Yew Tree & Gardens
Yew Tree House
Hale Milnthorpe
Cumbria LA7 7BJ
015395 63527
07813 897631
info@yewtreegardens.co.uk
www.yewtreegardens.co.uk

Ref - 4540-P04-Proposed Site Plan_2017.09.27

Windy Arbour, revised site access

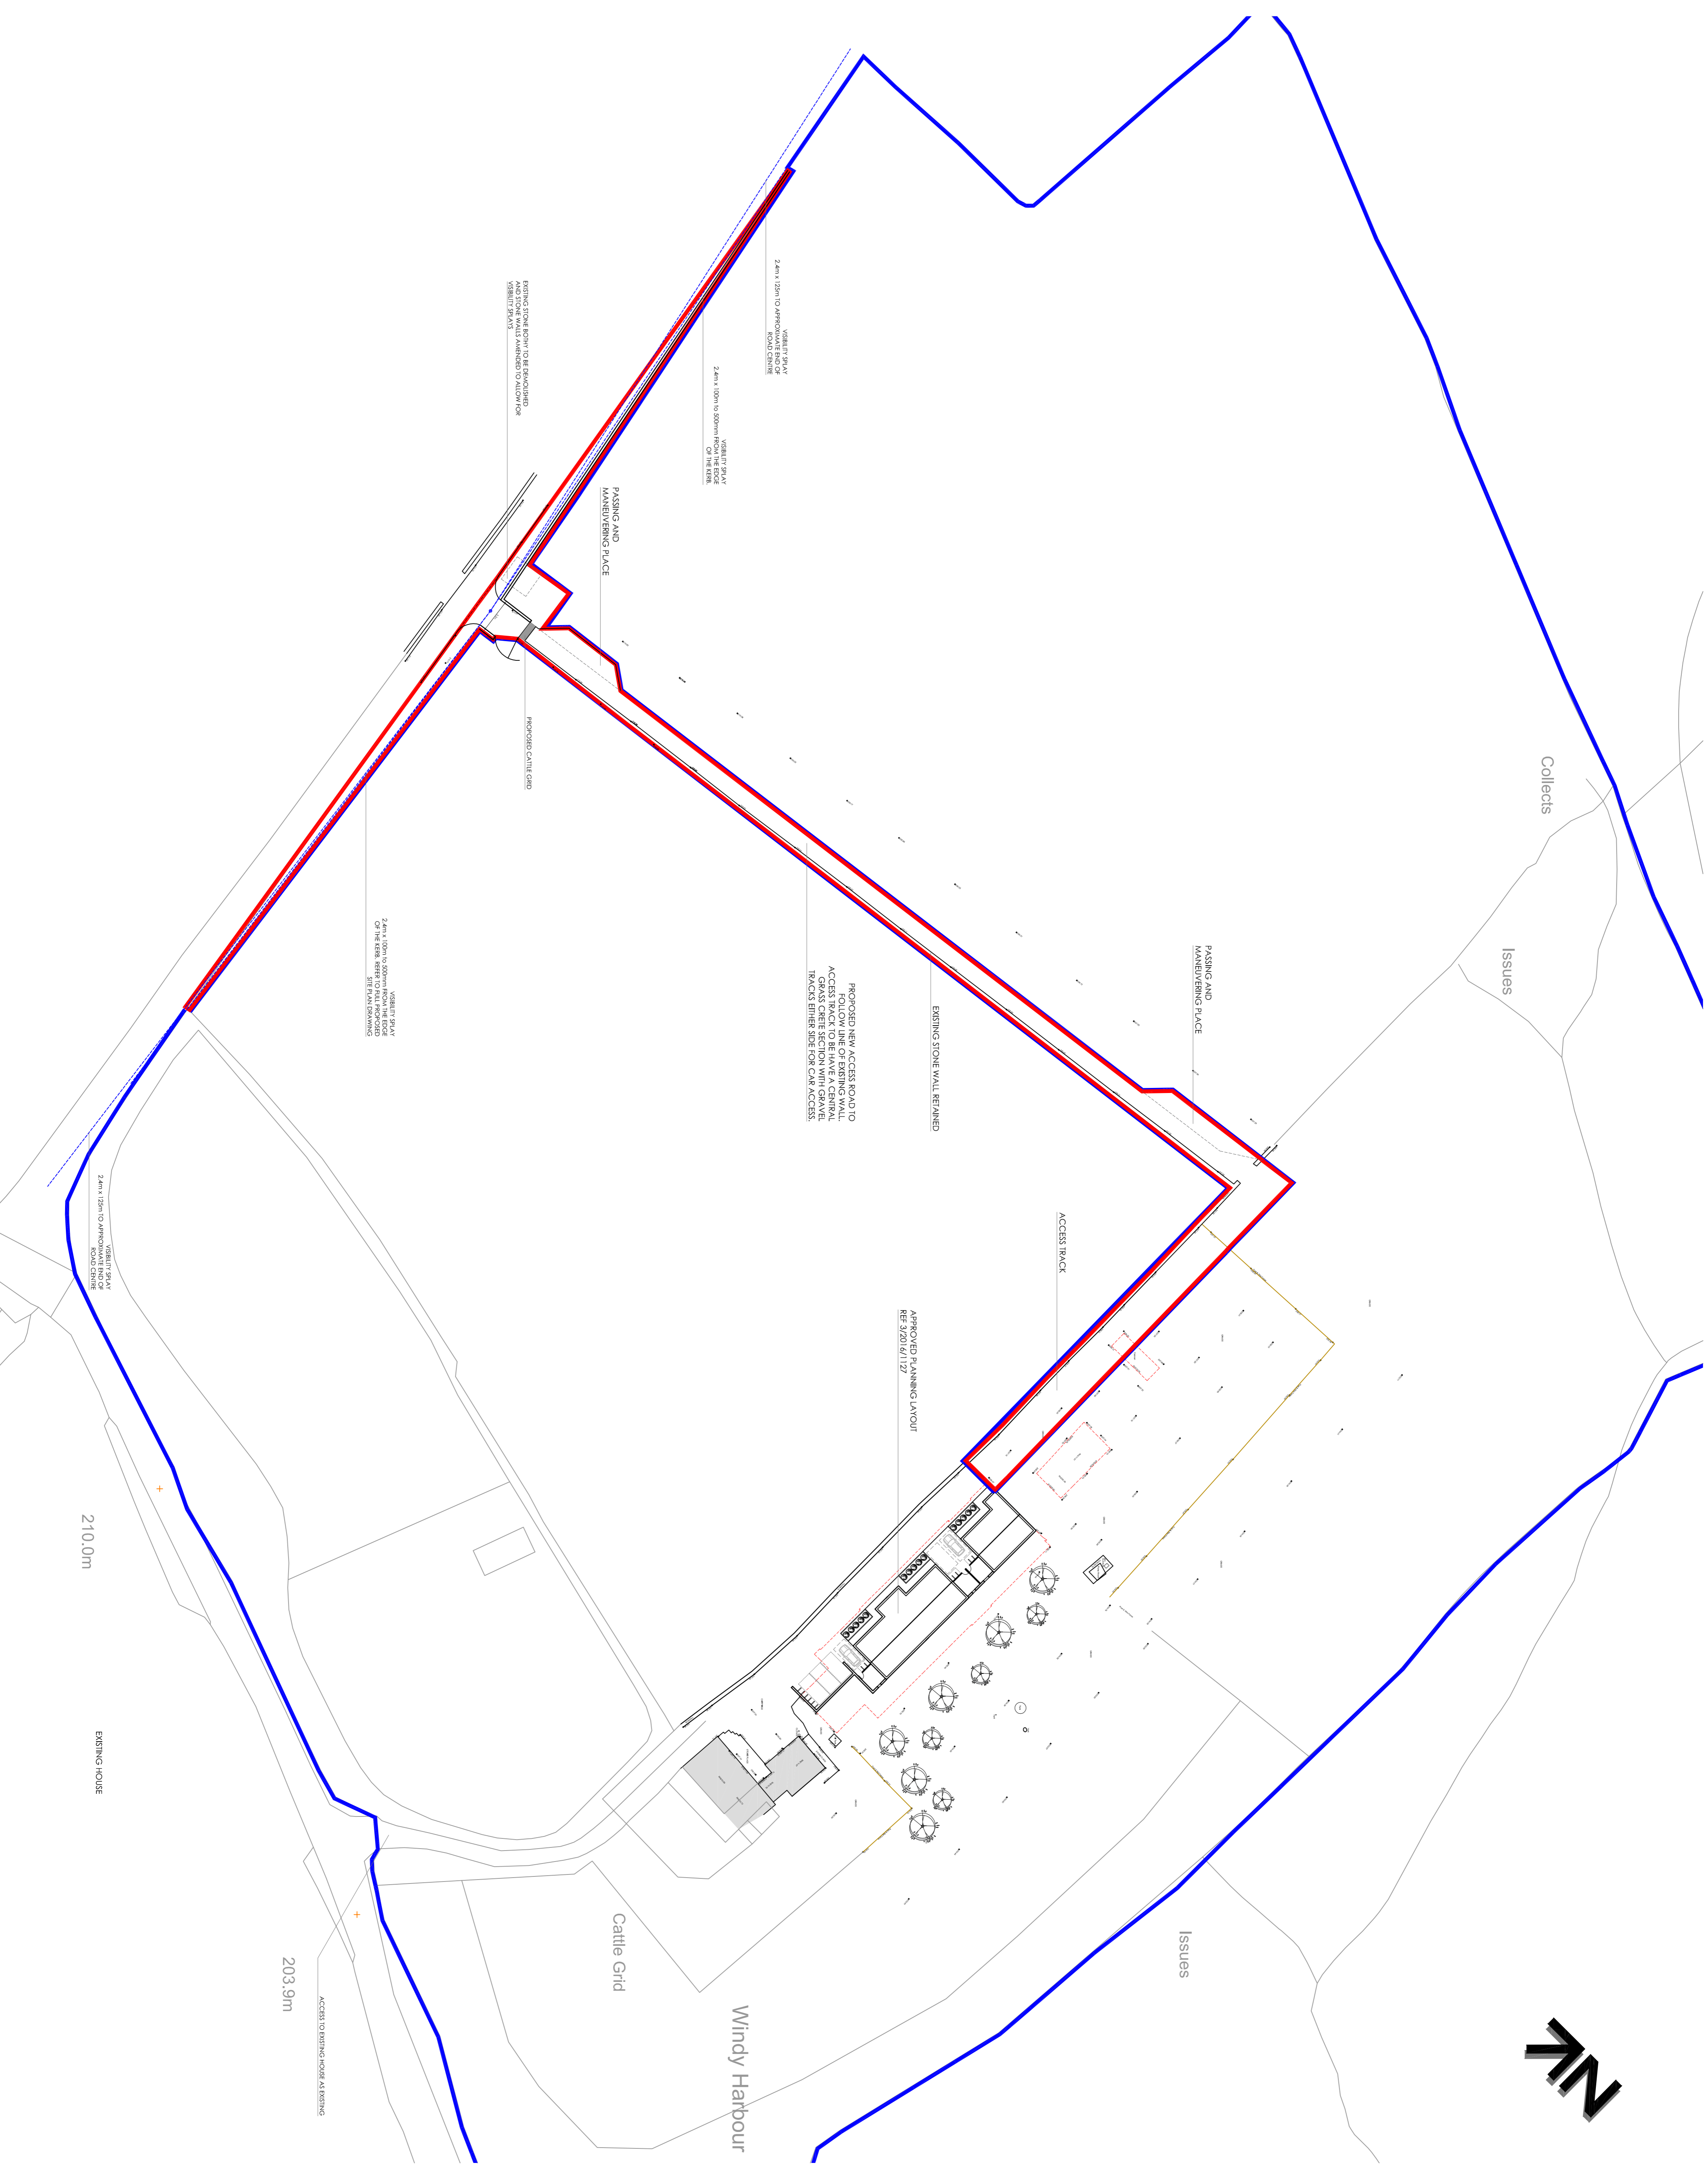
Firstly, the proposed access route will be based upon an existing field entrance and an associated area of hard standing and a building currently used for livestock handling. Whilst the building and surrounding network of field boundaries are of traditional stone construction common to the area, the roof of the building is of modern metal profile sheet material and the hard standing is concrete.

The proposal will require the removal of the existing building, the widening of the access point with realigned walls and construction of a single width access route adjacent to the existing field boundary wall. This proposed route is to be formed from two gravel surfaced tyre tracks with a central grasscrete strip, no other structures are indicated in relation to the access route.

The existing field boundary walls, landforms and surrounding topography screen the proposed route from all identified receptors to the East, North and South East of the site. Visibility of the access route from the South and South West will be limited to transient receptors immediately adjacent to the highway entrance. We estimate that the presence of existing hard surfaces combined with the limited period of visibility of the access route would not have a magnitude of impact greater than negligible adverse. The proposed materials would give the access an appearance that would be sufficiently agricultural in appearance so as to not introduce a structure of obviously residential nature.

The removal of the existing agricultural building will have an impact of minor adverse magnitude, we are of the opinion that this magnitude would be greater if the building were not roofed with modern sheet materials. This treatment has reduced the significance and contribution of the structure within the context of the surrounding agricultural landscape. The limited scale of the building means that its contribution is restricted to a relatively small area immediately to the East and West of the building's location.

Due to the surrounding topography, visibility of the location of the proposed access route will be experienced from elevated land to the West of the site, as illustrated in receptor points N to Q.

Receptor points in the elevated land around Parlick Fell are situated at between approximately 400m and 1.5km from the proposed access route. This distance from the site will make the removal of the building and realignment of the walls achieve an estimated magnitude of none.

Similarly, the access route is located immediately to the West of the existing field boundary and is at in excess of 500m from the elevated receptor points. As this wall currently forms a strong, visible linear component from North to South we are of the opinion that the proposed materials and juxtaposition with the wall will make the access route subsidiary to it. Our assessment would therefore be that the proposed scheme would have a magnitude of impact in the order of negligible adverse to none.

With regards to landscape character impacts, similarly to the visual impact assessments the proposed access would have a limited impact upon the immediate surrounding landscape. Our assessment would be that the removal of the vernacular building, realignment of walls and formation of the track would have some degree of adverse impact upon the landscape character. This is based upon a change from the current site; we estimate that this is likely to be in the order of minor adverse at construction to negligible adverse with surface and material weathering at 15 years post development
